Development Facilitation Team (DFT) – Review Comments

Project No: PR-2019-002042 Date: 07/24/2024 Agenda Item: #2 Zone Atlas Page: M-09

Legal Description: Lots 1-75, Tracts B and 1 thru 4, SOMBRA DEL OESTE

Application For: SD-2024-00124-PRELIMINARY/FINAL PLAT (DHO)

This Sheet shows
Pre-Plat Conditions and
Vacated Easements

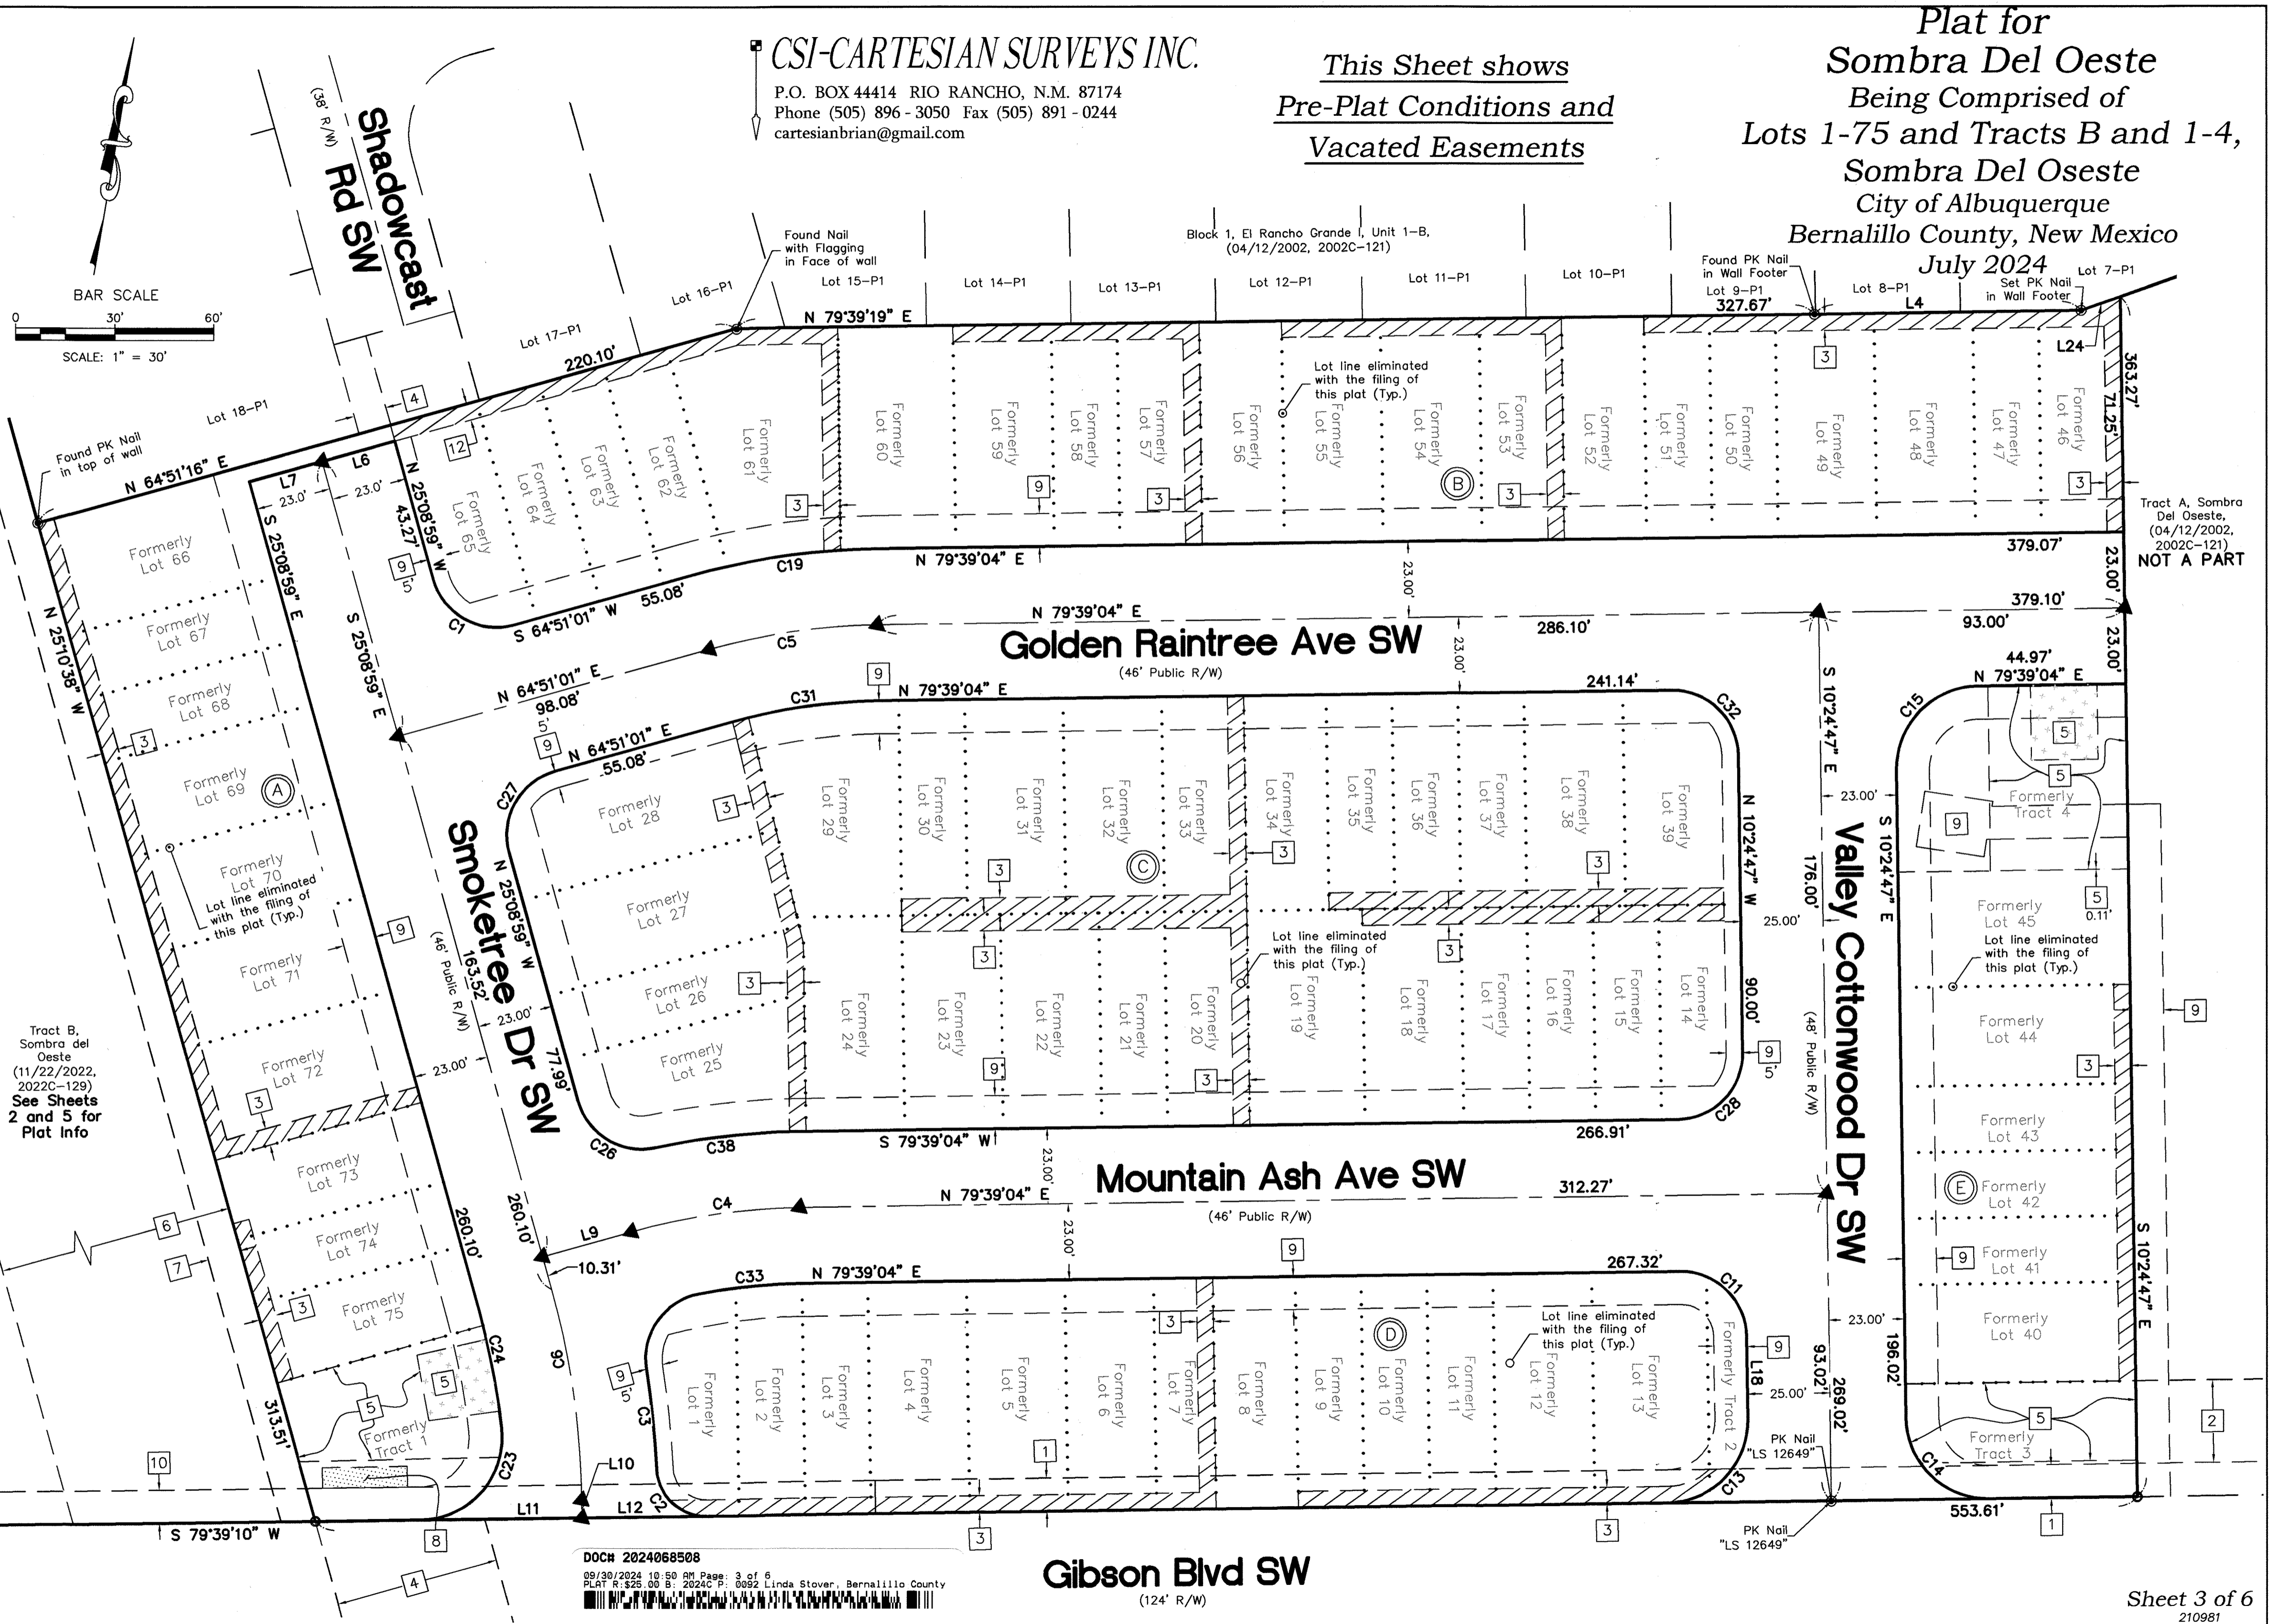
- The Applicant proposes to vacate the private drainage ponding easements as marked in blue and to vacate portions of the easements [3] marked in green in the above image.
 - Planning staff defer to **Hydrology/Transportation** regarding the compliance of the vacation of these private drainage ponding easements [5] with the DPM and IDO.
- The application number must be added to the Plat.
- The AGIS office must approve the DXF file and proof of approval must be provided prior to final sign-off of a plat.
- Please confirm that **no** changes to the infrastructure list is required for this request.
